M3 Junction 9 Improvement

Scheme Number: TR010055

7.12.7 Statement of Common Ground with Cycle Winchester

31 July 2023

DRAWING TITLE
**GENERAL ARRANGEMENT PLANS
 APPP REGULATION 5(2)(c)
 SHEET 3 OF 10
 DOCUMENT REFERENCE: 2.5**

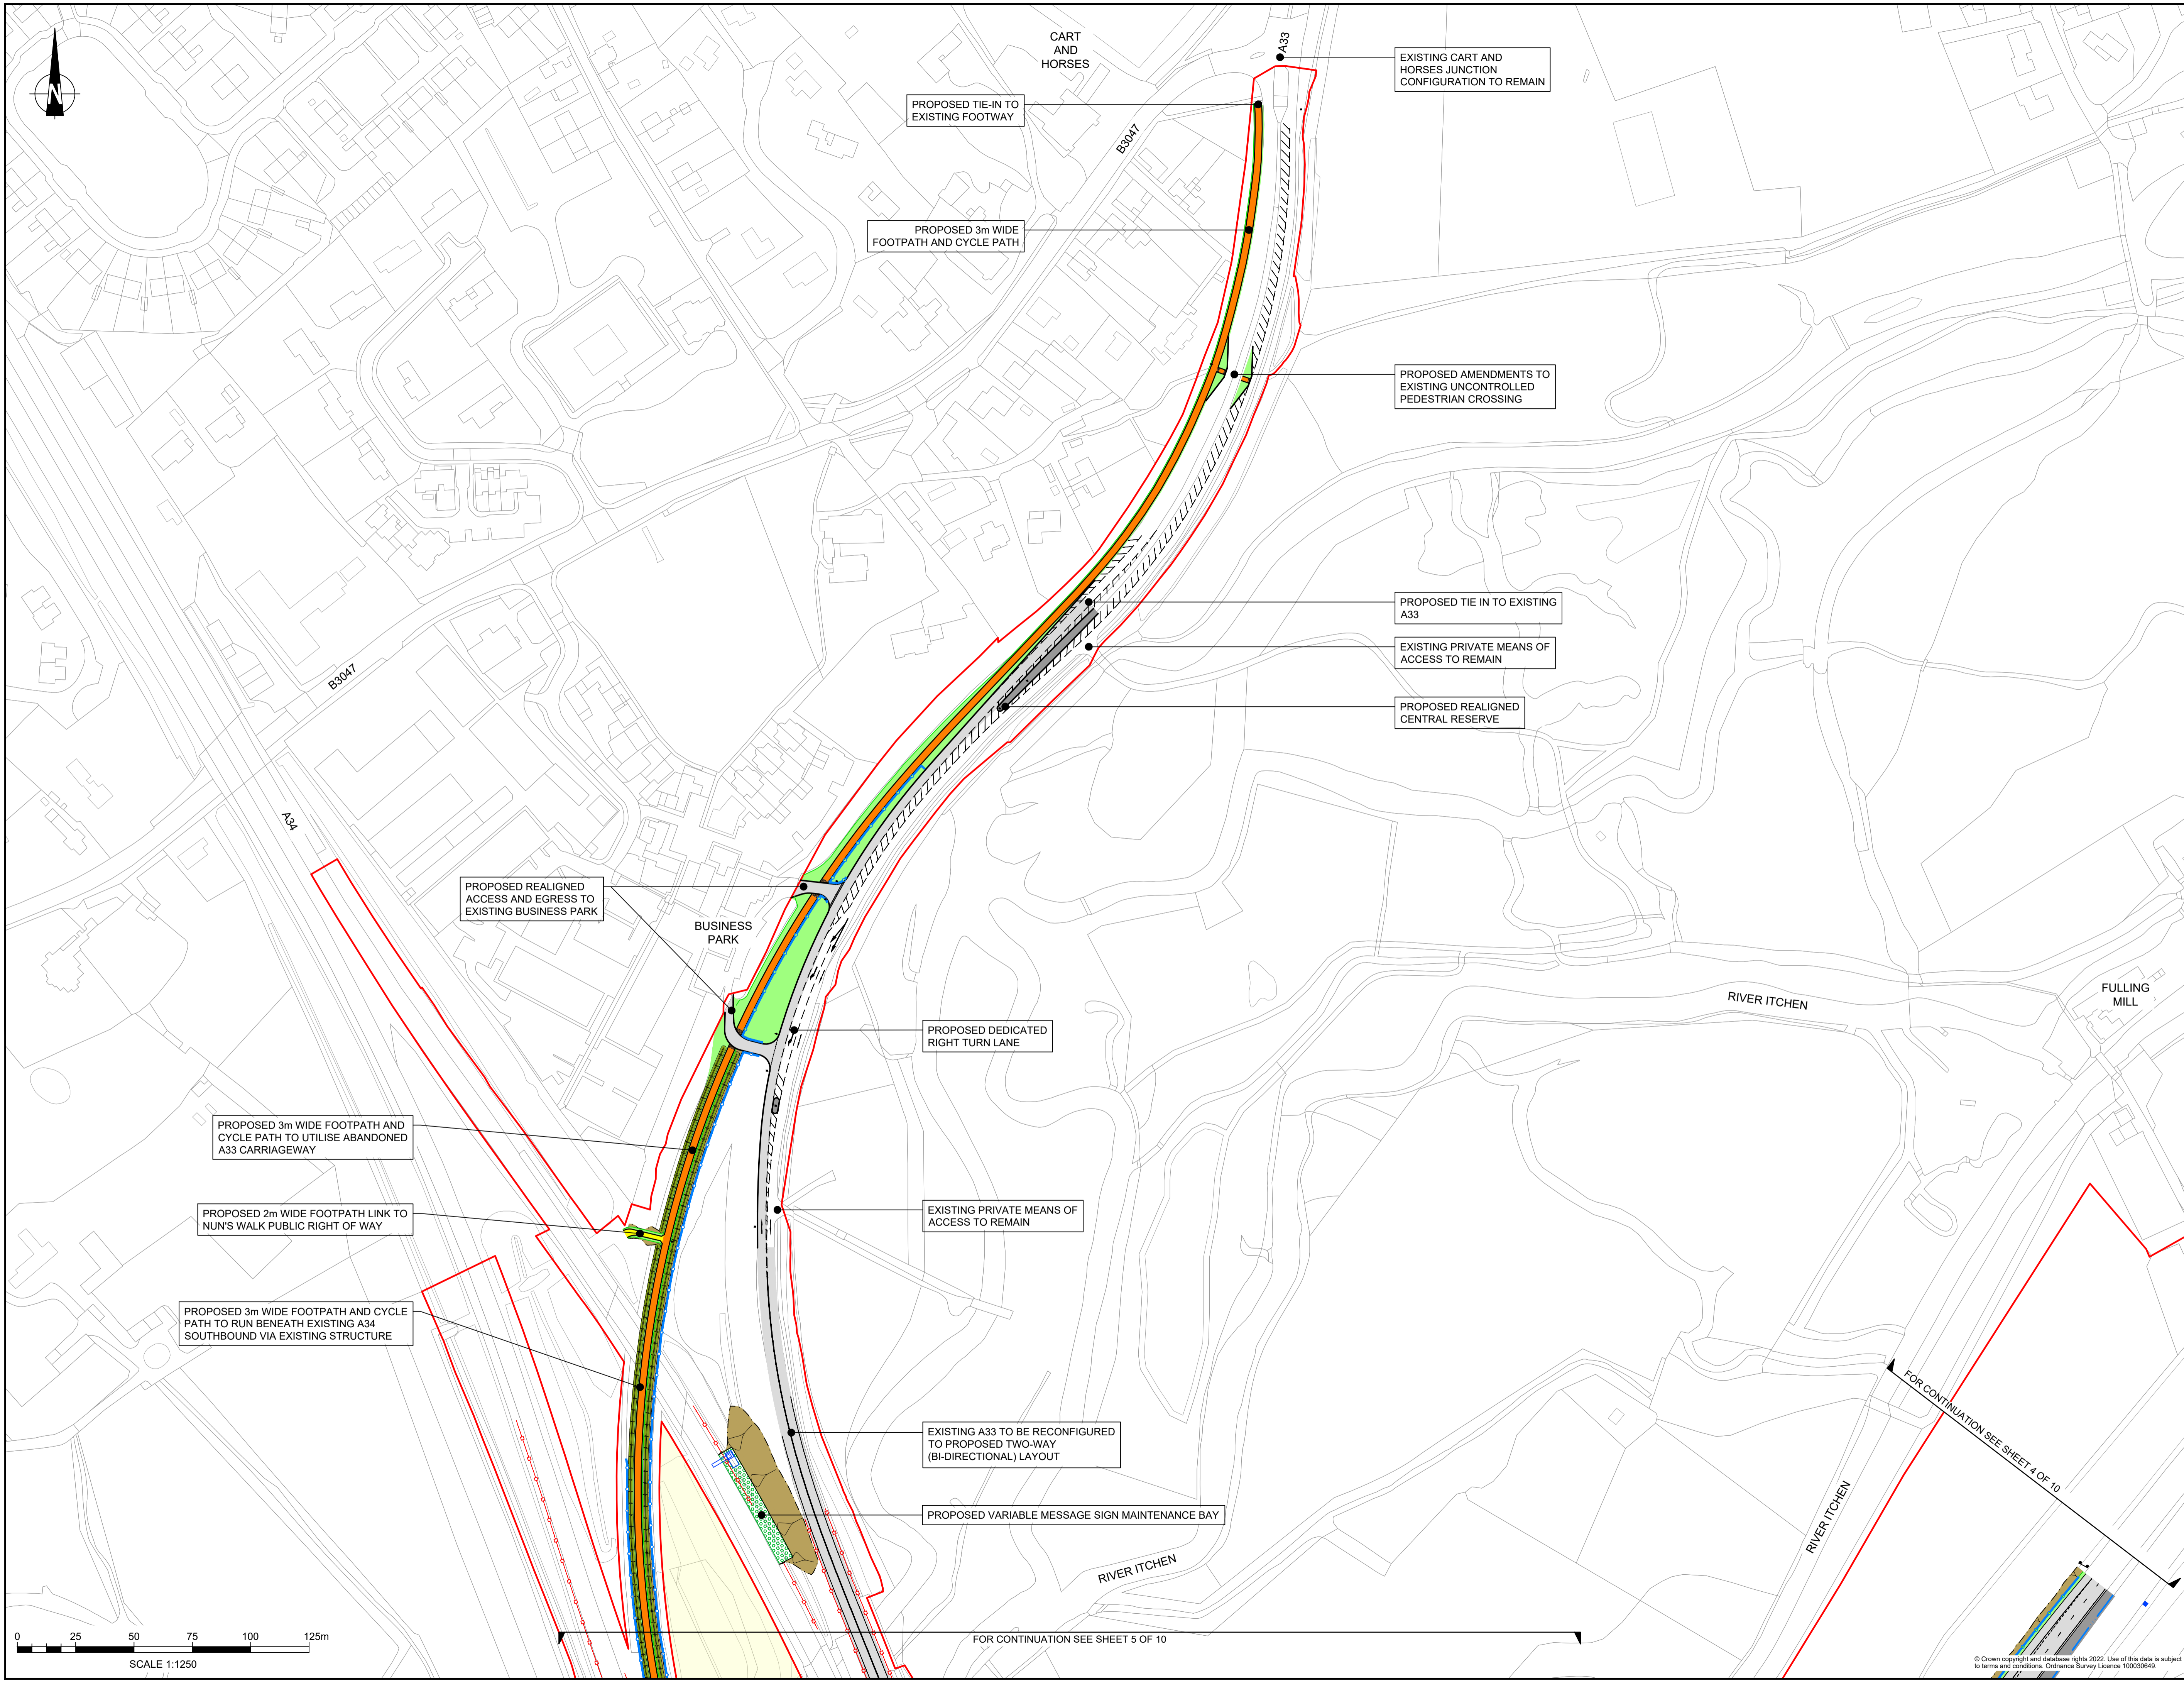
4.6	Winnall to Kings Worthy walking and cycling route Layout at the Cart and Horses junction	Sheet 3 of General Arrangement Plans (2.4, APP-009)	Cycle Winchester considers the linkage at the Kings Worthy end into the Hampshire County Council Road network to be unsatisfactory. In particular, this means the connection into the Cart and Horses junction between the A33 and B3047. Hampshire County Council is proposing to improve this junction; the new route should link safely and conveniently into the proposals for the junction. At present it's not clear to us how this would happen. If Hampshire County Council comes up with a technically viable position then National Highways should contribute to the funding using designated funds.	The proposed walking and cycling route ties into the existing footway / cycleway at the Cart and Horses (Kings Worthy) end of the scheme, which is existing Hampshire County Council provision. Future changes to the highway at the Cart and Horses junction are outside the Scheme and will need to be brought forward by Hampshire County Council.	Under discussion	28 July 2023
